Subject: REDACT AND UPLOAD Representations re - Planning Application: 3/2021/1262

Thank you for the notification of the Application by William Pye Ltd to build 4 commercial units. I do not have any major concerns or objections about the Application itself other than the below and would request the following Planning Changes and Assurances are sought:

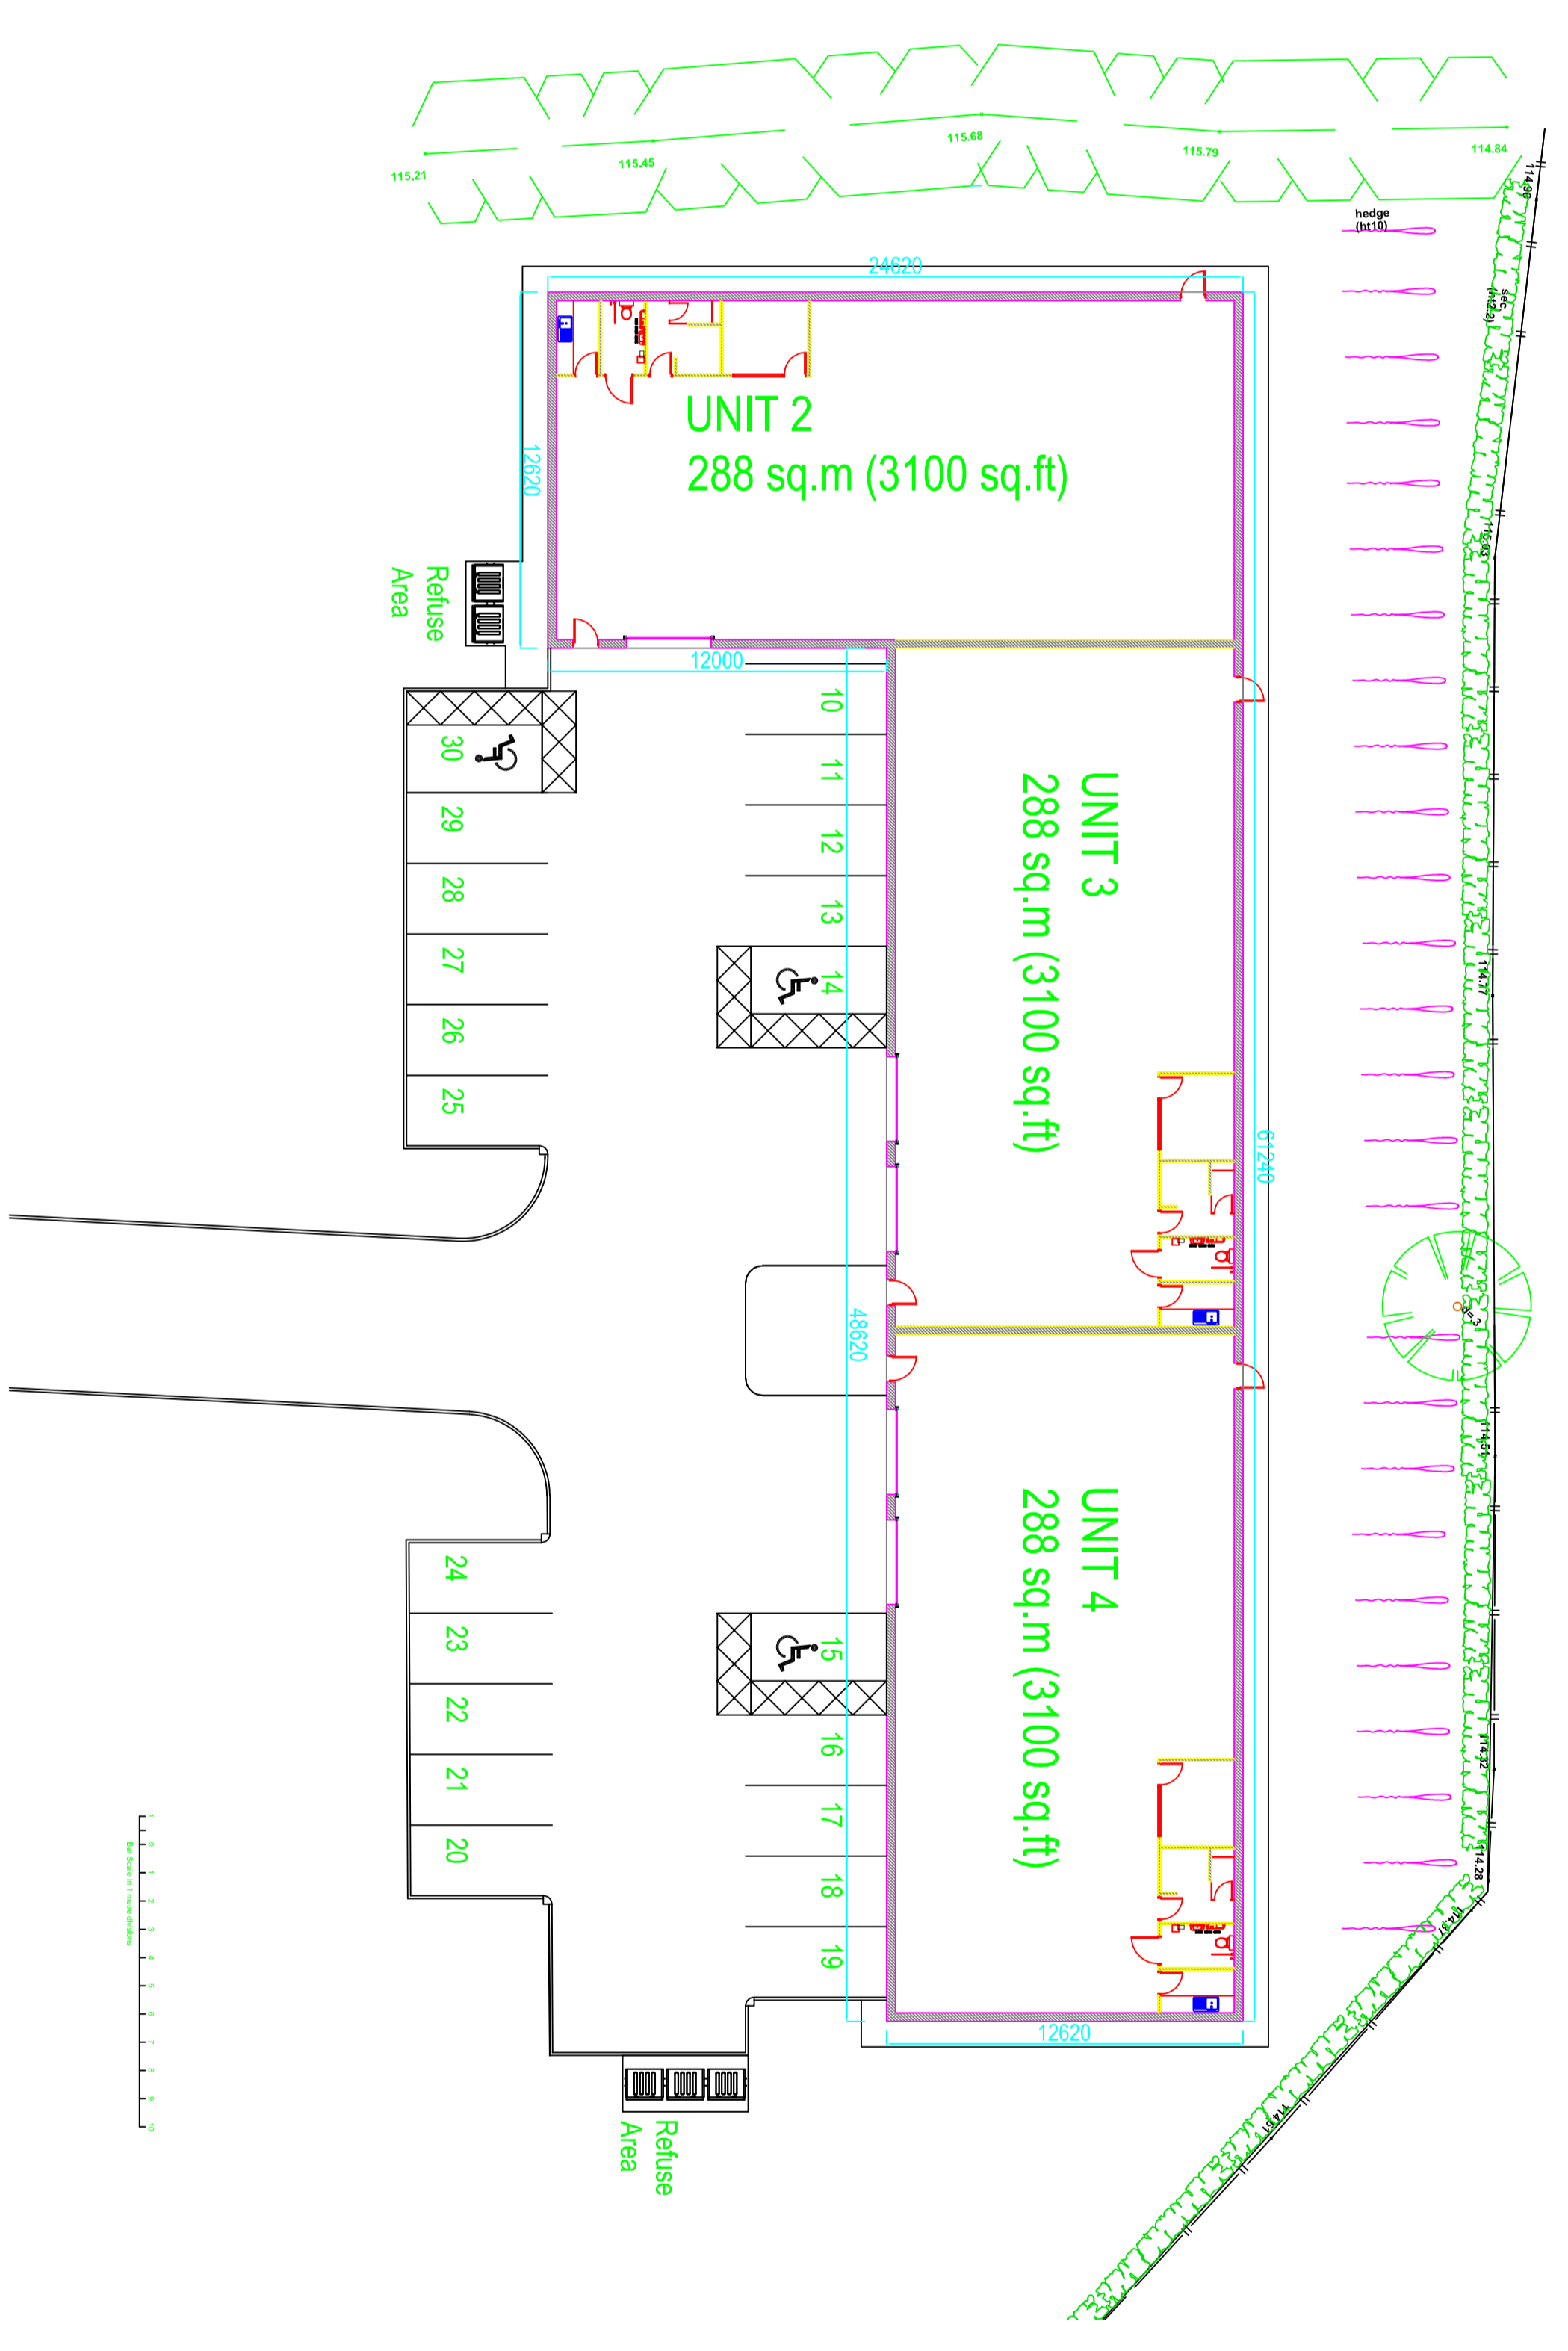
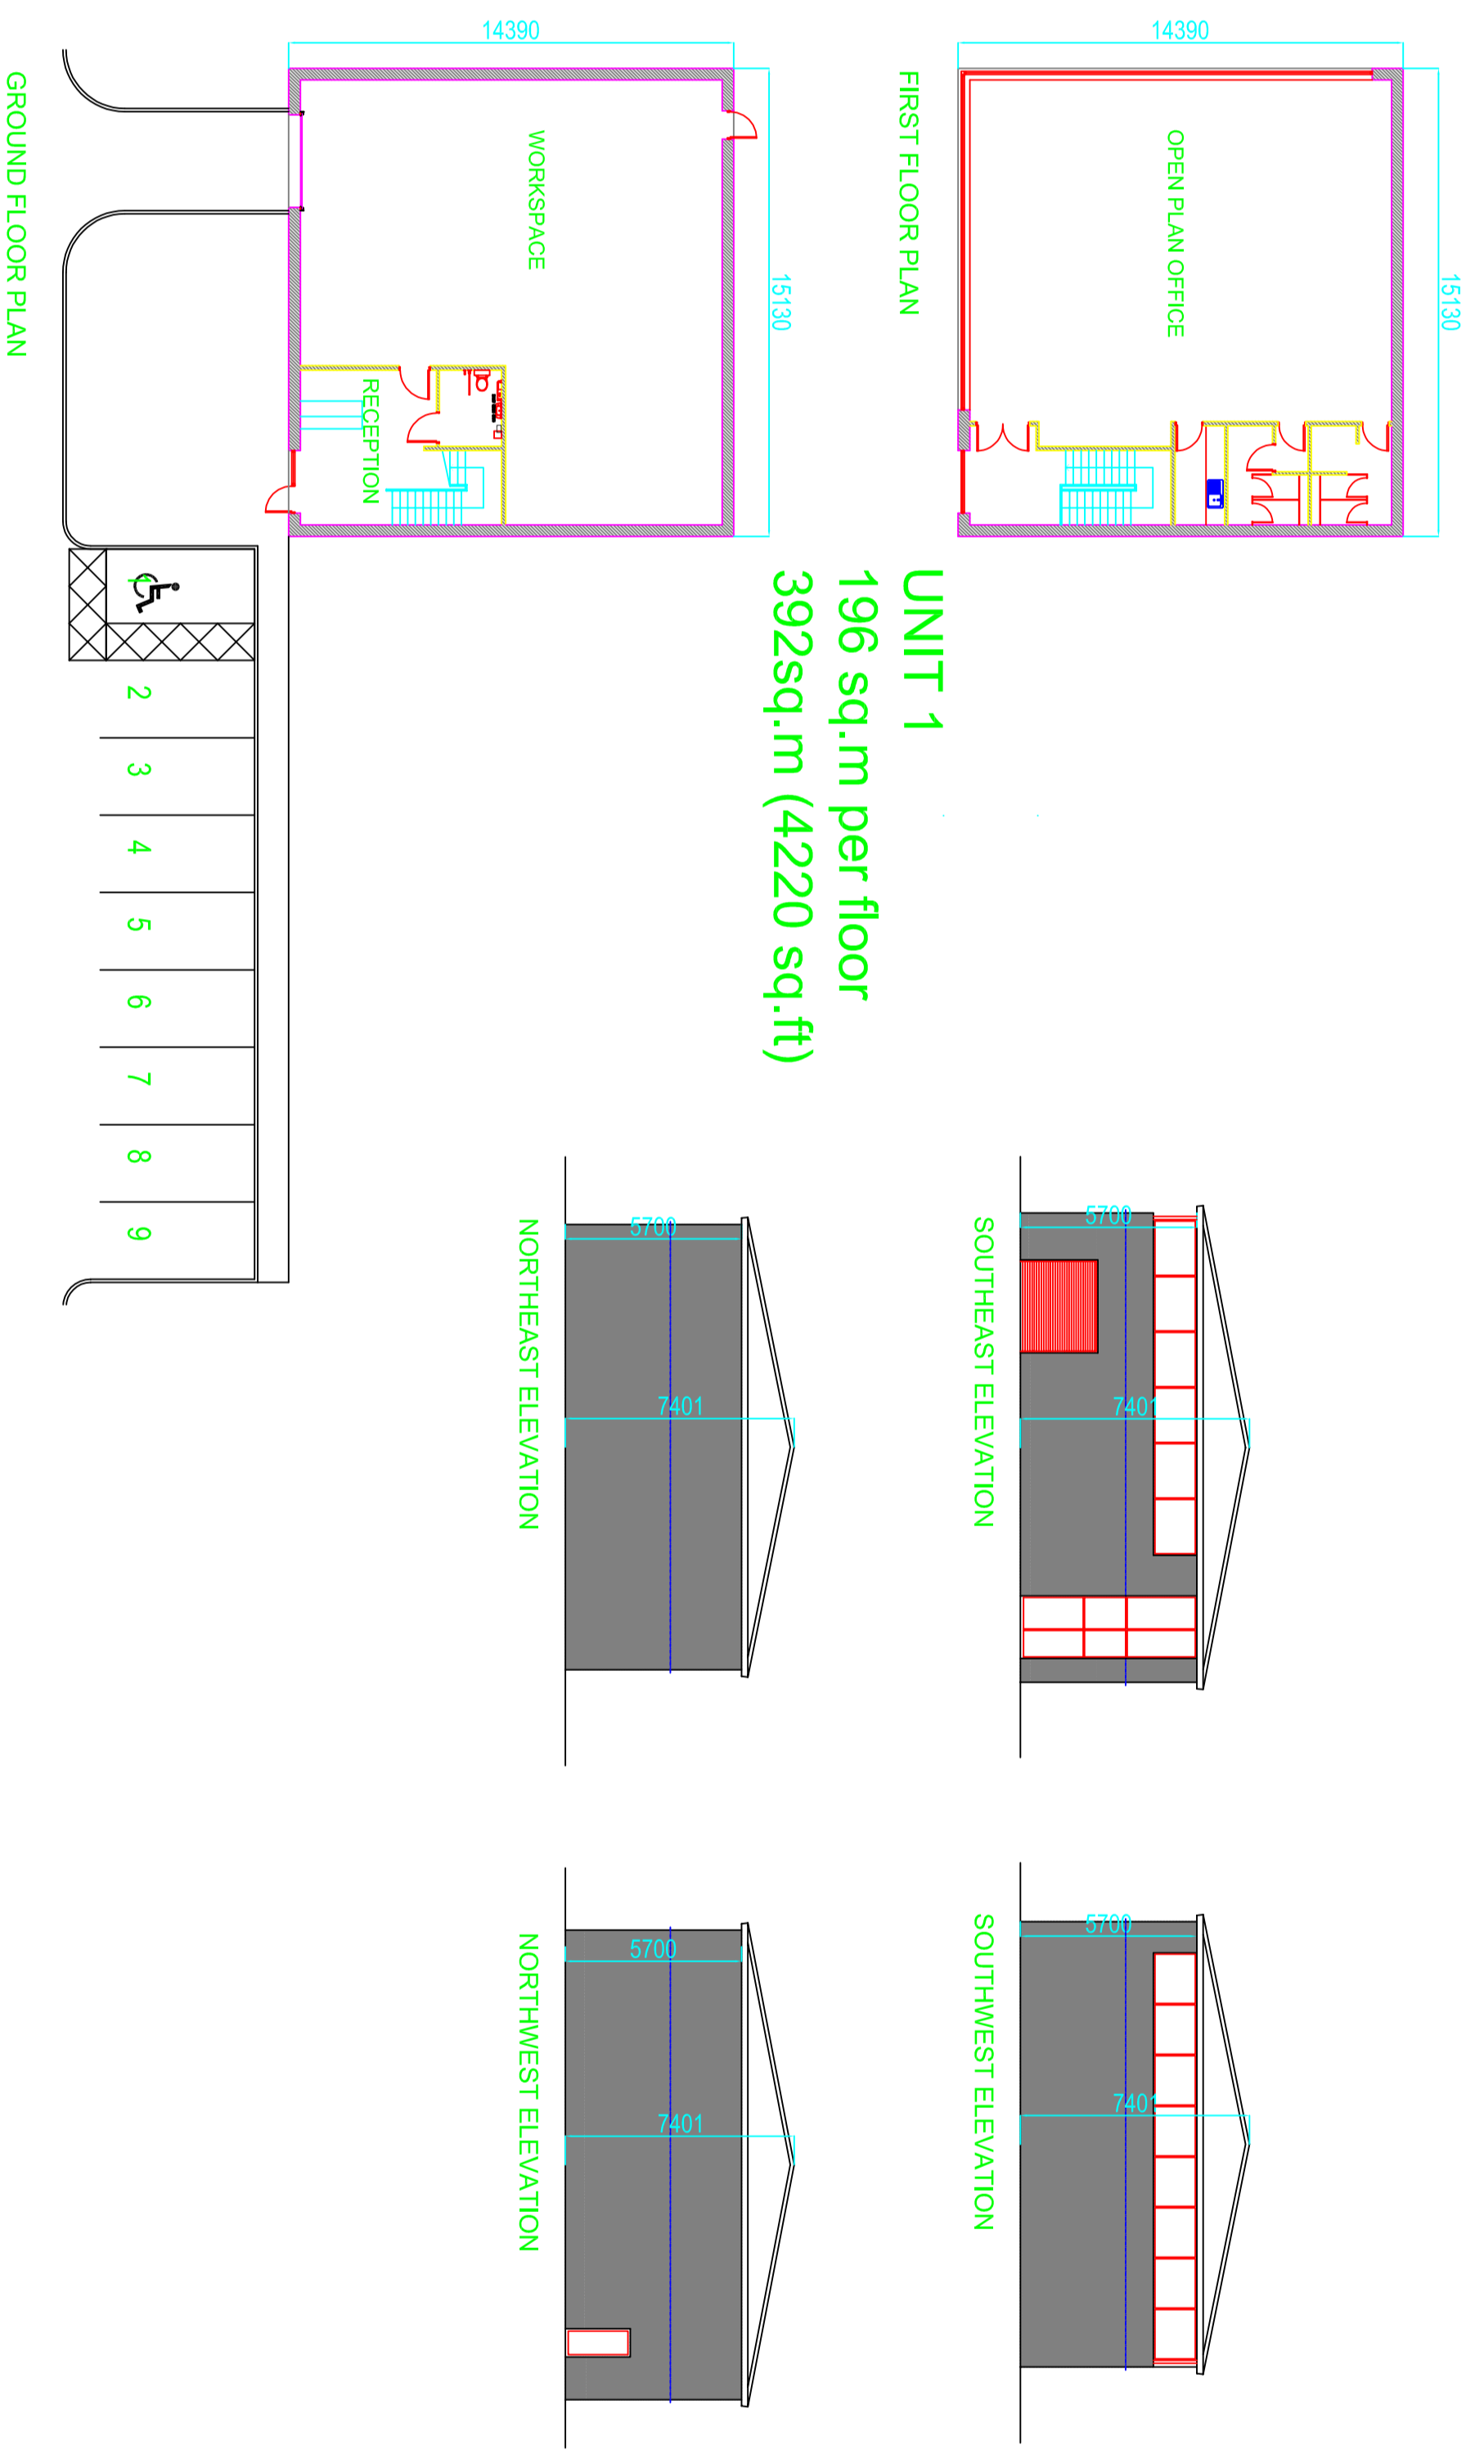
I would seek a change to the Plans to include some additional landscaping on the South boundary of the new development to soften the view from properties 40 to 30 Chapel Hill of the front and side elevations of the proposed new development. Much of the proposed landscaping only benefits Little Lane and the School as neighbours, which quite frankly only have limited view of the new development compared to 40 to 30 Chapel Hill.

Due to the 'hill' nature of the bordering Chapel Hill it is unfortunate that the neighbouring 40 to 30 Chapel Hill properties, which sit lower down on Chapel Hill, will be able to see most of the front and side elevations from their rear upper windows whereas the Little Lane neighbours, who have been considered, will only see the roof line out of their rear upper windows. In fact some selective planting of a few new mature trees to replace the numerous mature trees that were previously removed to clear the land for Application 3/2019/0753, at the boundary of 40 to 36 Chapel Hill would also soften the view of the recently completed commercial unit build (Application 3/2019/0573). After all this site borders the Conservation Area and whilst I am sure we all acknowledge the Importance of commercial development it is important that the overall 'feeling' of the Conservation Area should be preserved for the good of Longridge.

Please see below for suggested areas for some more soft landscaping.
